From: Adam King [REDACTED]
Sent: 16 September 2019 18:13
To: Zac Denton <Zac.Denton@arun.gov.uk>
Subject: RE: K/19/19/HH Little Tangle, Middle Way, Kingston Gorse

" K/19/19/HH Little Tangle, Kingston Gorse. The proposed development involves more than a simple extension to the existing property. The proposal involves raising the roof height to 15.4 metres creating a new dwelling level at first floor height and adding a balcony at that level. This would result in significant overlooking of the properties and gardens on either side of Little Tangle and there is no evidence in the application as to how this might be avoided or mitigated. Additionally, the proposal is to provide grey slate for the new roof and this would be out of keeping surrounding properties which are provided with clay tiles and/or Horsham stone and is therefore contrary to policy D DM1 (1) of the Arun Local Plan."

Drawing Title
Proposed Sections

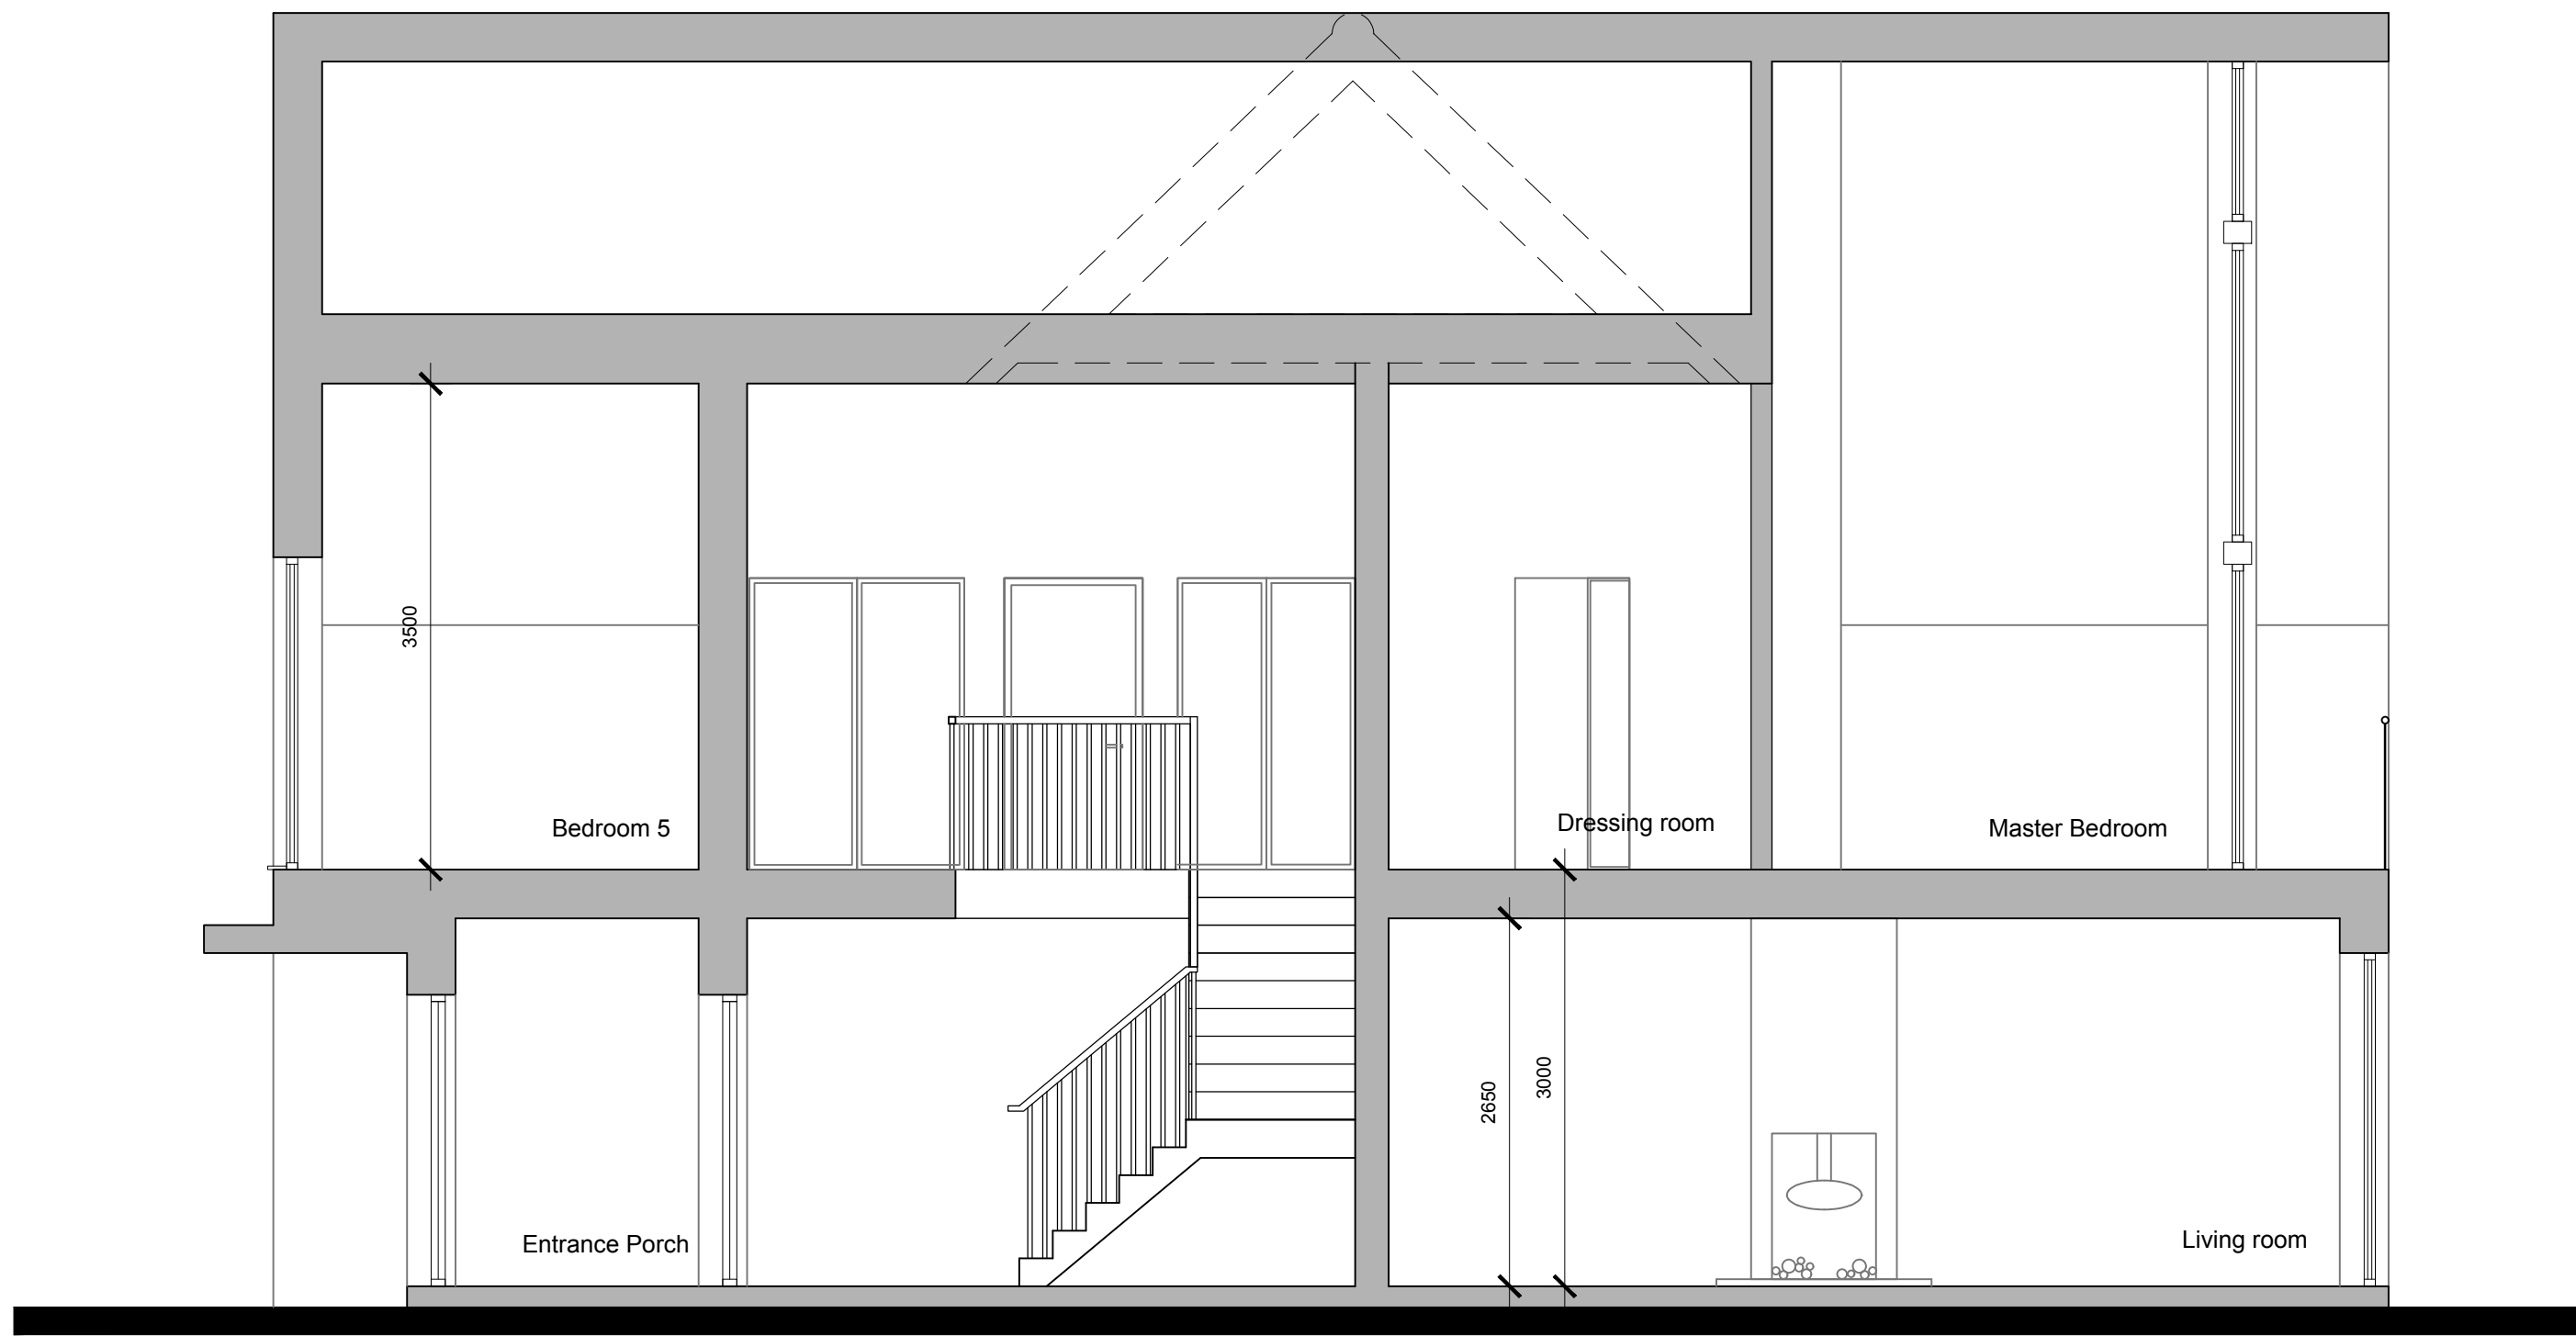
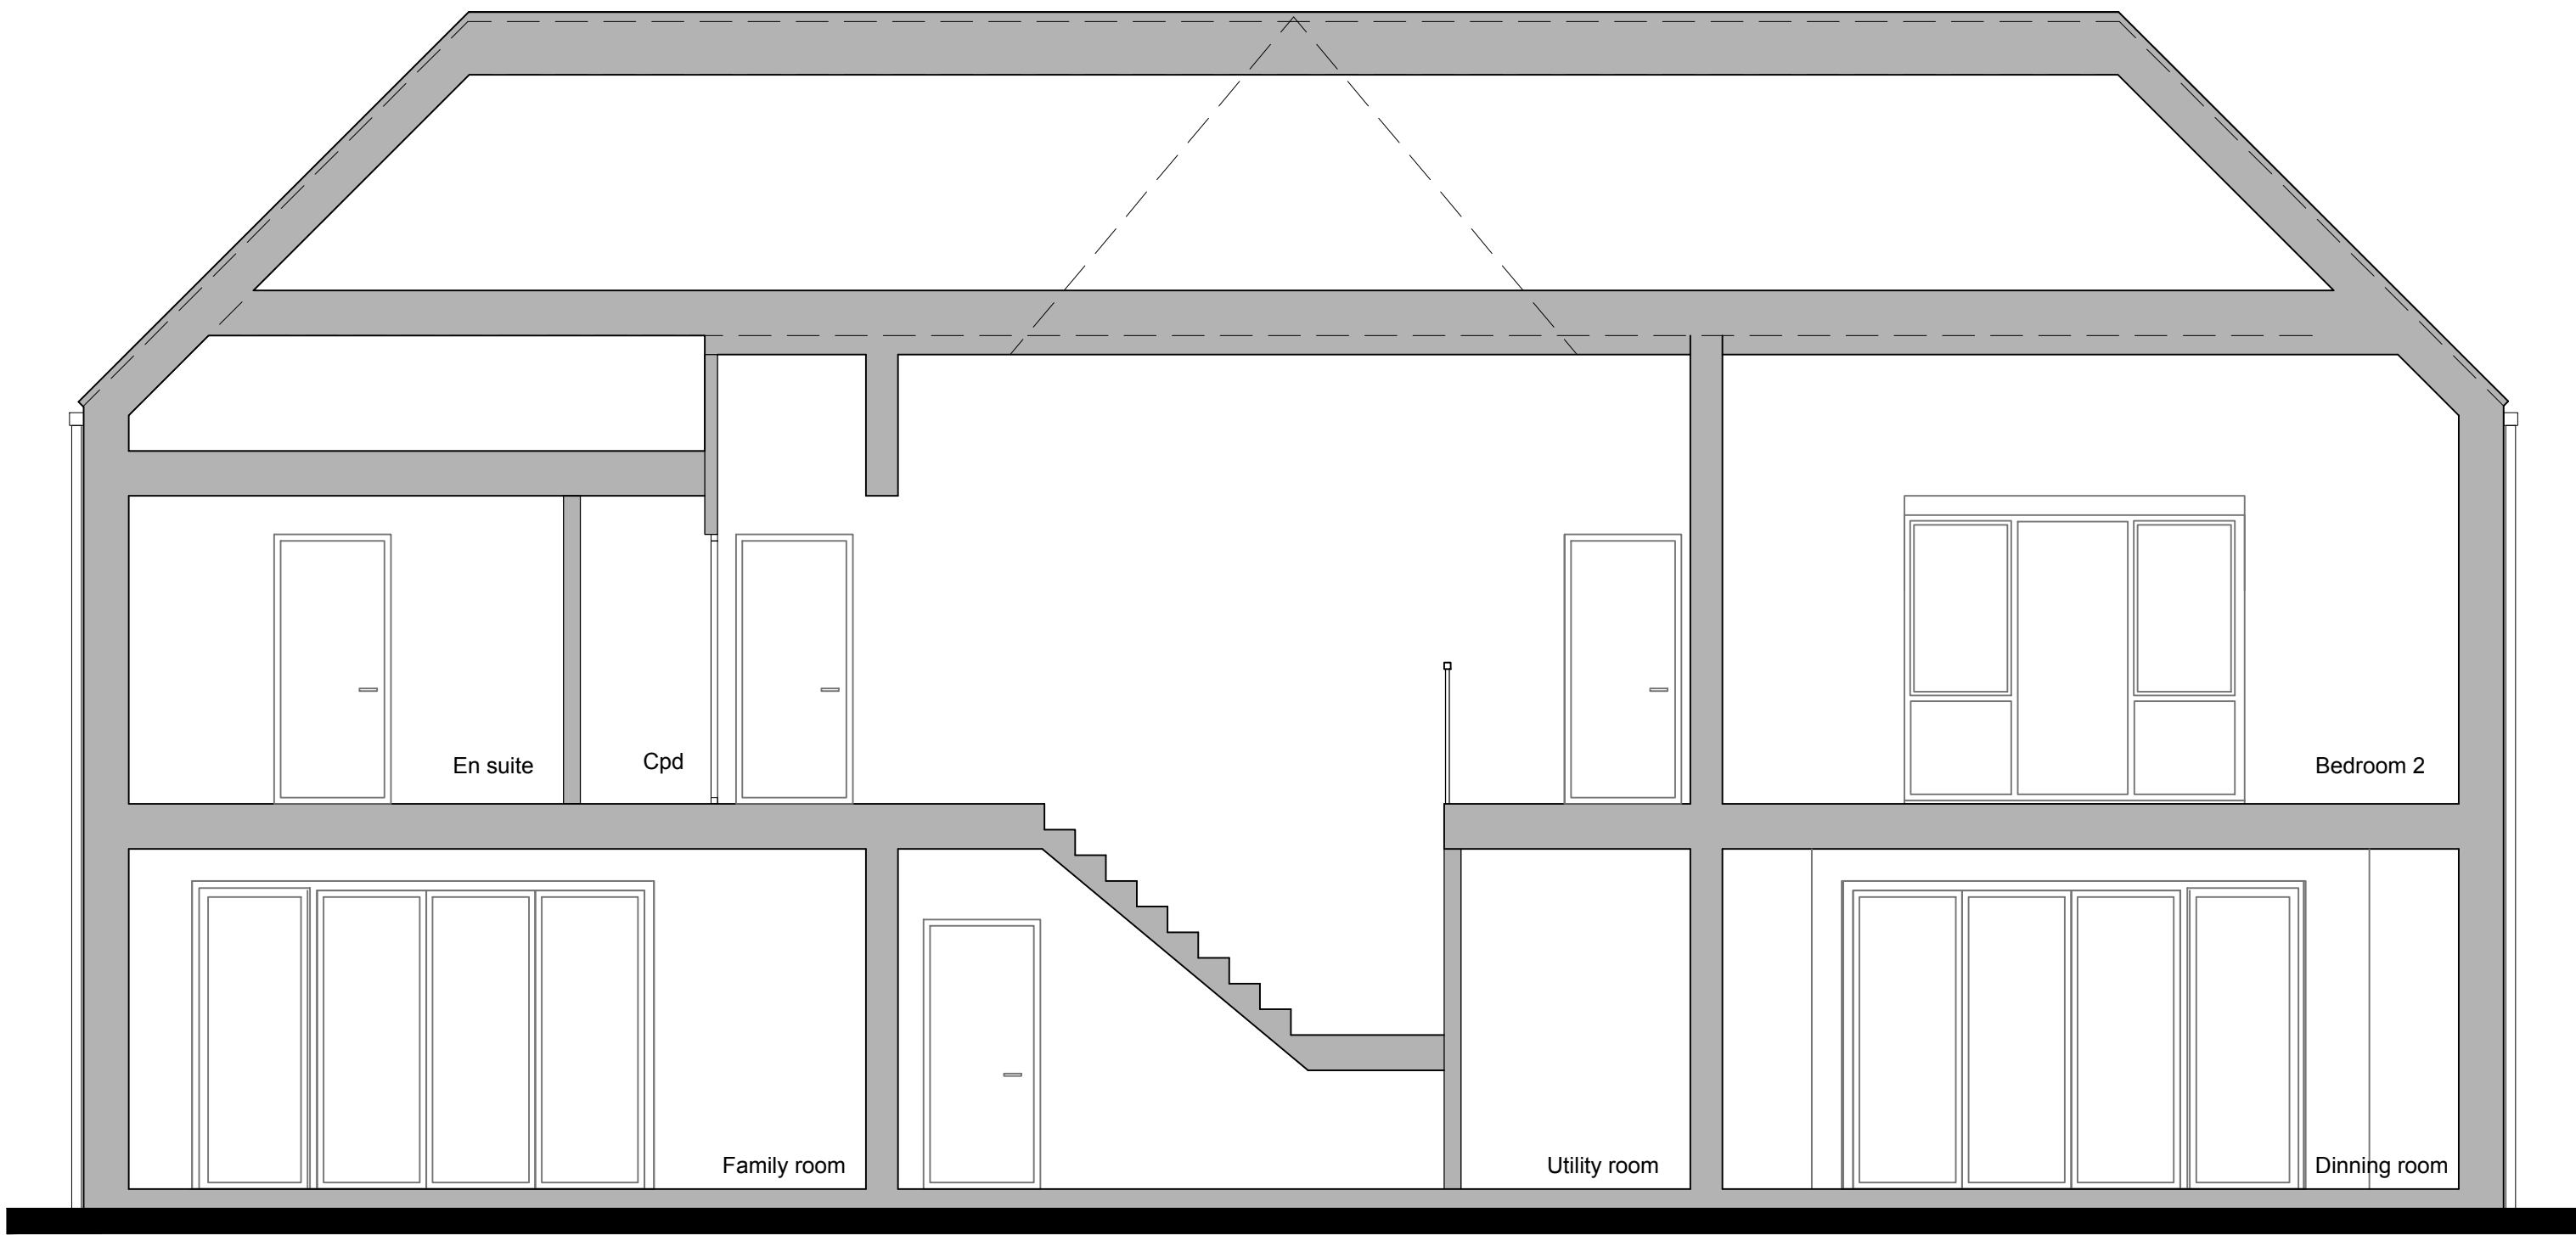
- The Cllr. notes that the proposal involves raising the roof height to 15.4 metres. As you know, this is the AOD figure from the survey information, and not a true height.

- To report accurately, the new eaves height from the ground is 4.652m high, and the **highest** point of the ridge is 9.320m high from the ground. The existing buildings ridge height is 6.080m high.
